Engineers Comments Regarding Surface Water Drainage

Application Reference:	P/59/25/DOC	Reviewer Reference:	ADC/EXT2/D2134/74
Planning Officer:	Amber Willard	Date of Review:	14.01.2026
Site Name:	Sefter Farm Pagham Road Pagham PO21 3PX		
Application Description:	Approval of details reserved by condition imposed under reference P/117/21/PL relating to condition number 7 - surface water drainage scheme.		
Assessment Number:	1 of 2

TITLE Existing Site Areas Plan			
SCALE 1:1,000 @ A3		PROJECT No. 24019	
REPORT TYPE DS		DRG. No. 07

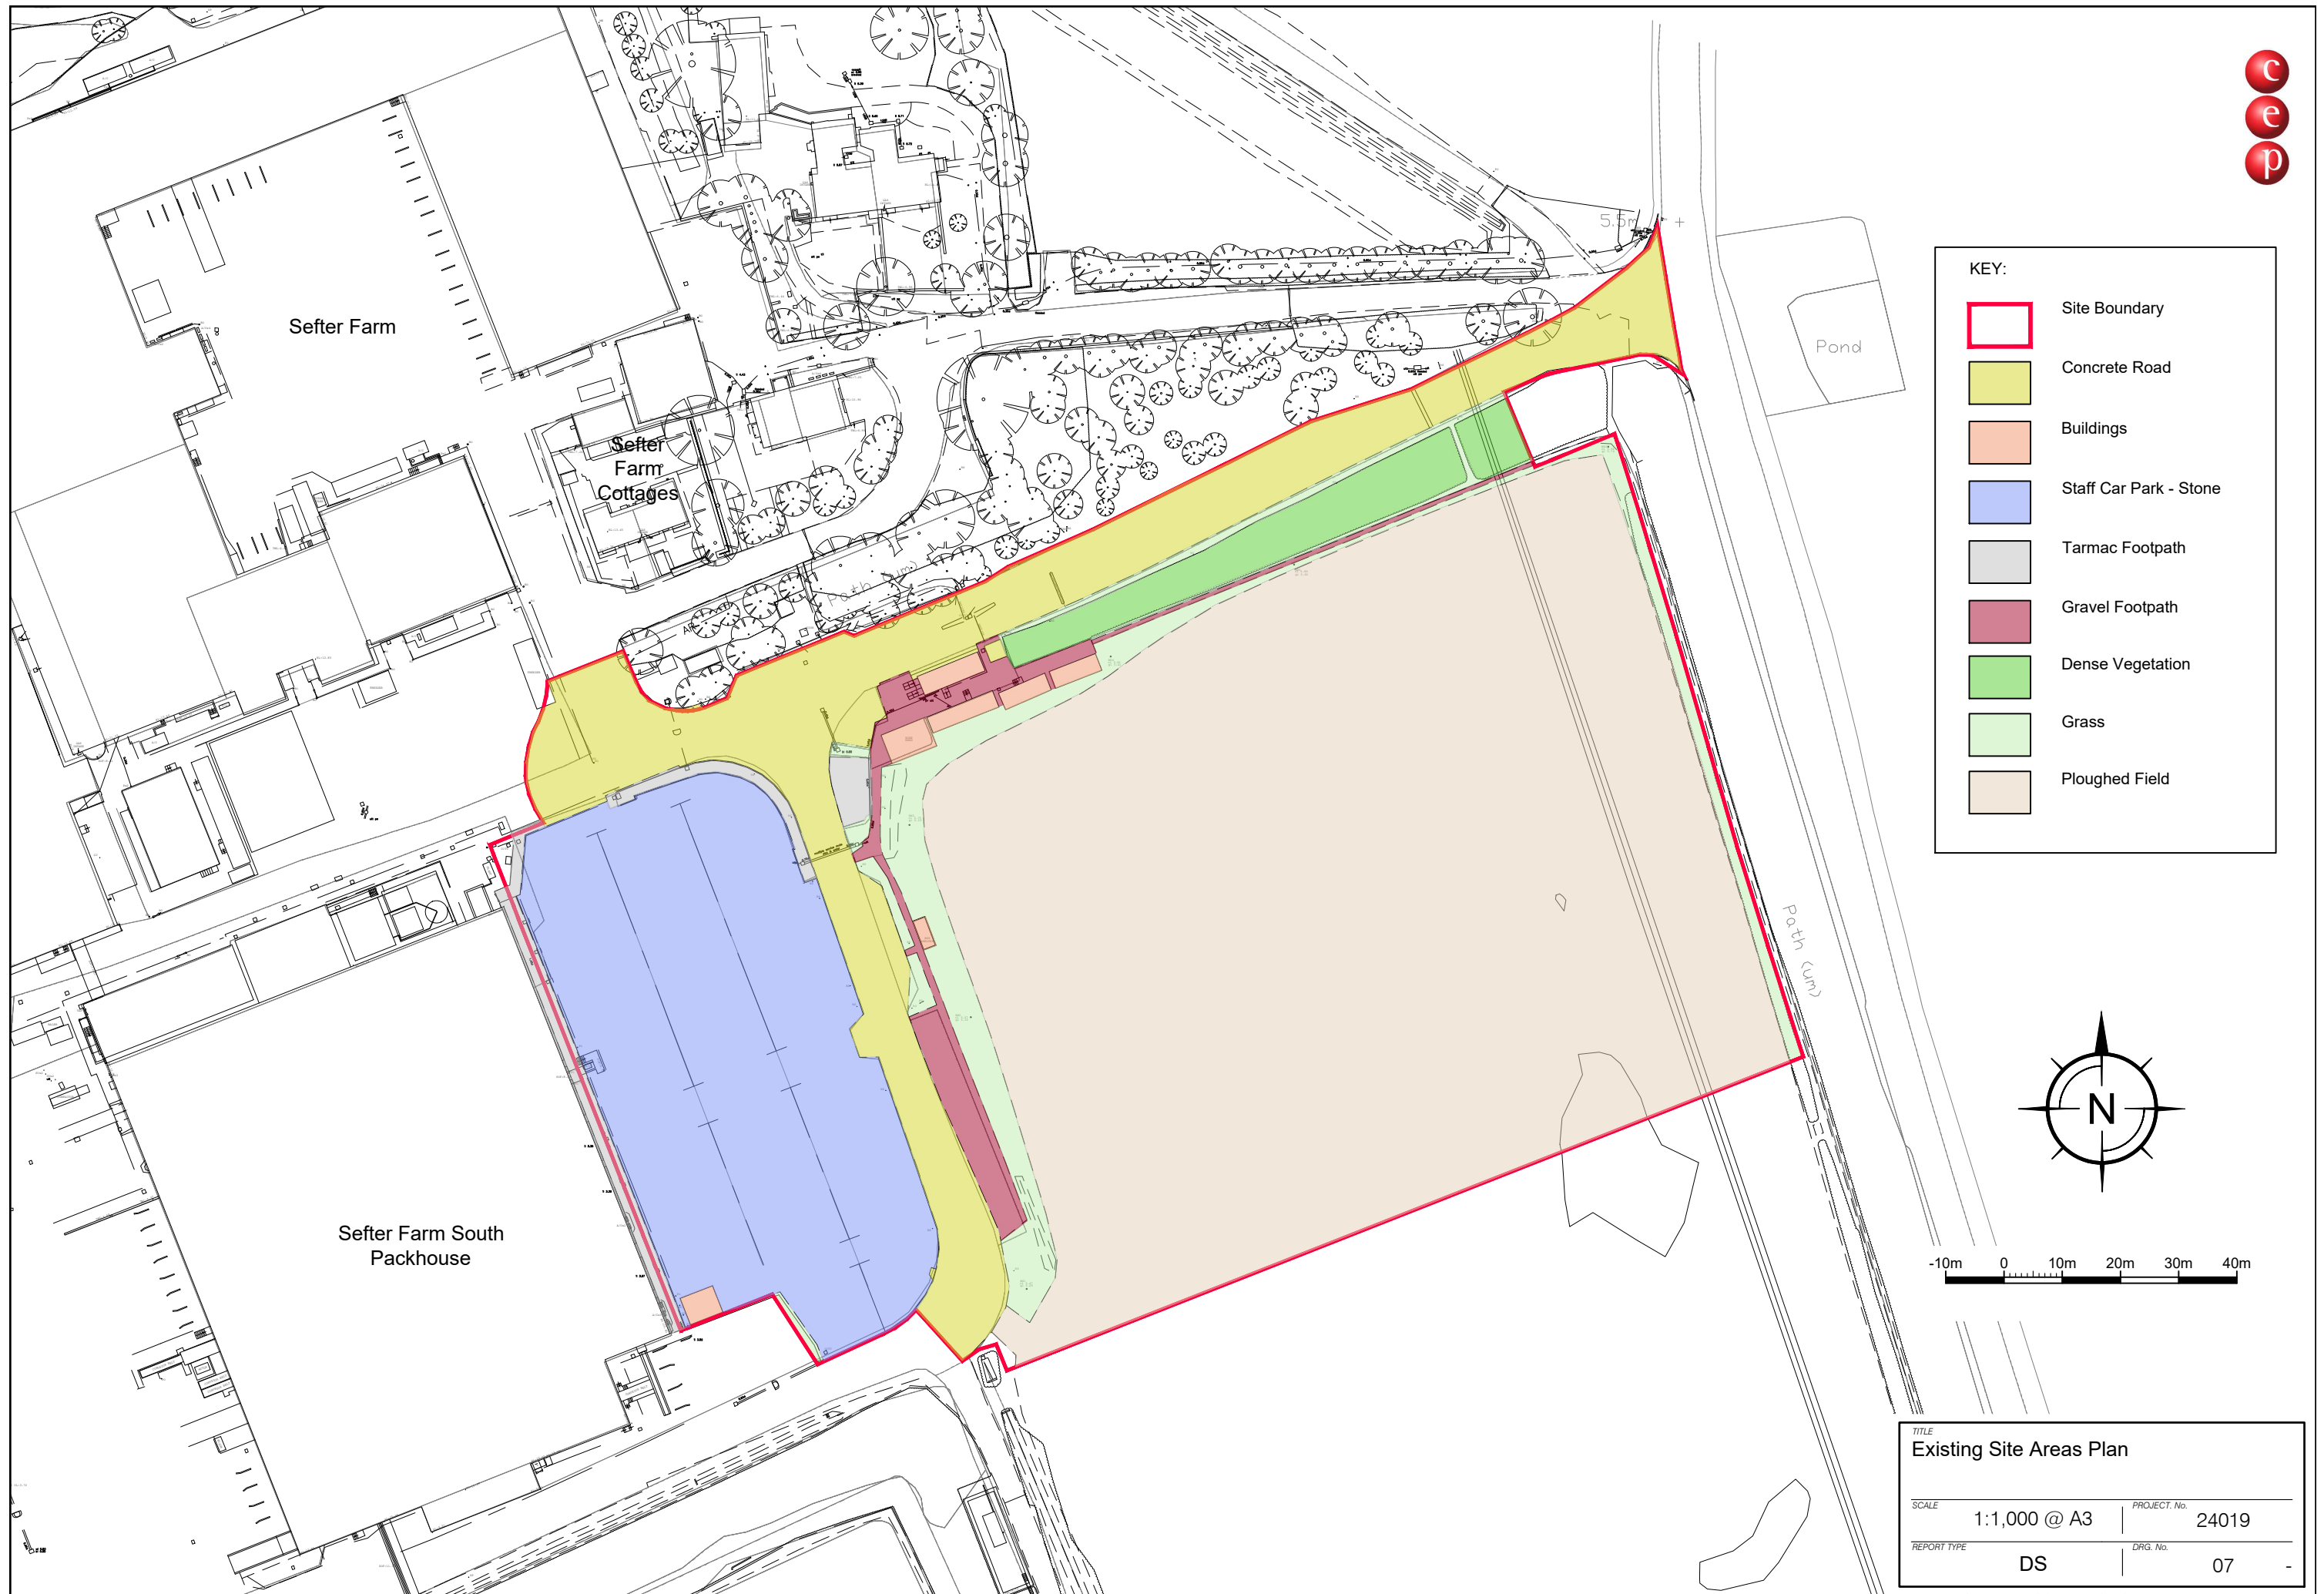
Designer Response 26/08/2025 Agreed. No further action required.				
3.	The drainage statement include 'proposed site layout and drained areas plan 03' which is accepted. However for completeness please provide similar drawing denoting the 'existing layout' and impermeable/semipermeable areas. Designer Response 26/08/2025 It is unclear why this is being requested. The proposed external surface is being increased by the development proposals. The design is based on those increased areas. Pre development runoff calculations are based on greenfield equivalent flows not the pre developed impermeable areas. This request is of no relevance to the site going forward and does not provide any useful information relating either to the approved planning	Noted. Plan 07 is sufficient. Comment closed.

permission or to the detailed design of the surface water drainage system We attach Plan 07 noting the current layout of the site and the current surfaces.				
4.	The QBAR rates are representative of the developed area being positively drained and are accepted. Designer Response 26/08/2025 Agreed. No further action required.	Noted. Comment closed.			
5.	Engineering drawing must show 3.0m buffer zone for all existing watercourses, including conveyance channels to consider access for maintenance and development impacts. Designer Response 26/08/2025 All existing watercourses and open channels are within the ownership of the site operator and have always been and will continue to be maintained from the top of bank. The conveyance channel is the only open feature that this could impact and is located next to the main concrete access road.	Noted. Comment closed.

DRAWN A Davies	DATE Apr 2025	PROJECT NO. 24019
ENGINEER S Doughty	CHECKED SRM	DWG NO. 202
SCALE 1:250 @ A1, 1:500 @ A3		REV. -

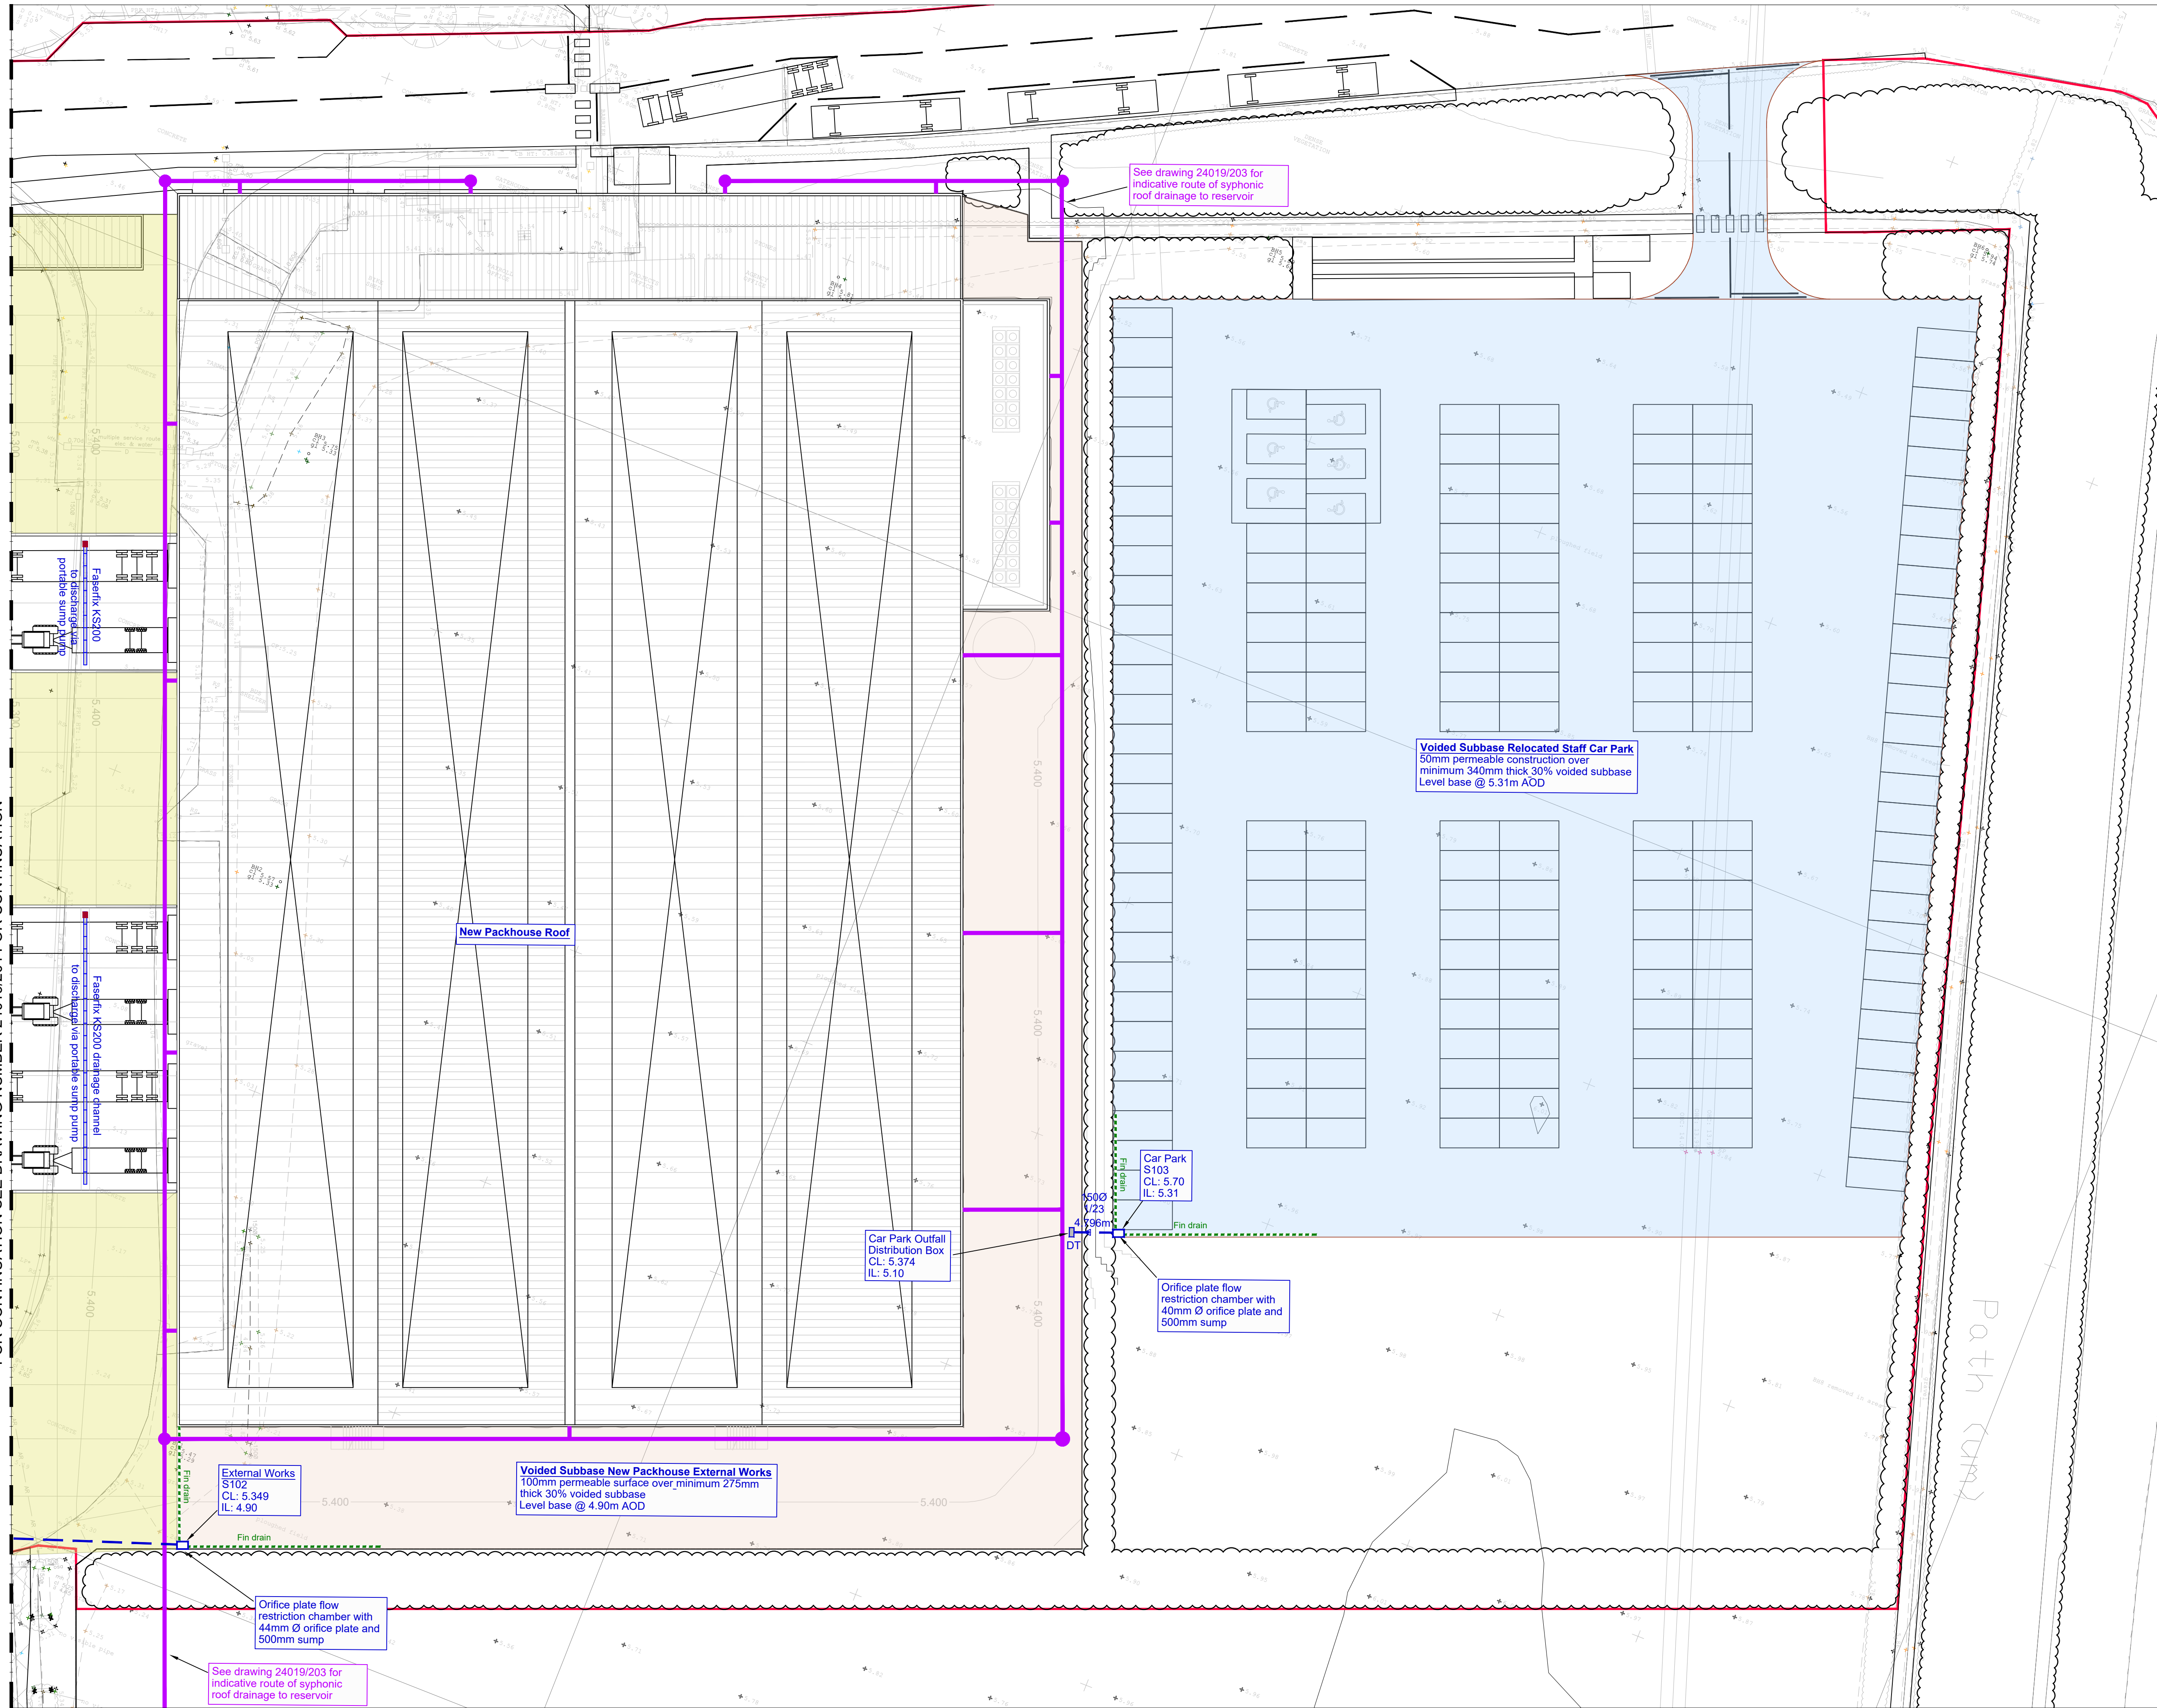
10.	Please provide supplier details/quotes for all flow control devices/sump requirements. Designer Response 26/08/2025 All flow controls are orifice plates. These can be sourced from a multitude of suppliers. There are no hydroborates or bespoke flow control devices propose on this scheme. Flow control manhole construction details have been added to Drawing 511 C, copy attached	National Standards advises '3.22 Where the peak allowable discharge rate requires flow controls with orifices (or equivalent) with a diameter of less than 50mm, the flow control shall be robustly protected from blockage risks. Regardless of this, the risk of blockage for all flow controls shall be assessed and mitigated against' The bespoke flow control details on drawing 511, with 40mm size are a relaxation to the above clause and therefore the designer must clarify on how the risk of block has been assessed and mitigated. This may also require further clarification for maintenance. Comment outstanding.	The orifice plates provided are restricting flows from voided stone beneath either permeable paving or concrete slabs with upstream catchpits and distribution tanks, each system collects surface water from the voided stone in fin drains which have a permeable membrane surround. There is no risk of any material of sufficient size passing through the permeable stone or membrane surrounding the fin drains and reaching or blocking any of the proposed orifice plates. The orifice plates are therefore robustly protected from any potential blockage risk. The locations of the office plates are indicated on drainage drawings 201 and 202 as previously submitted.	Noted. Comment closed.
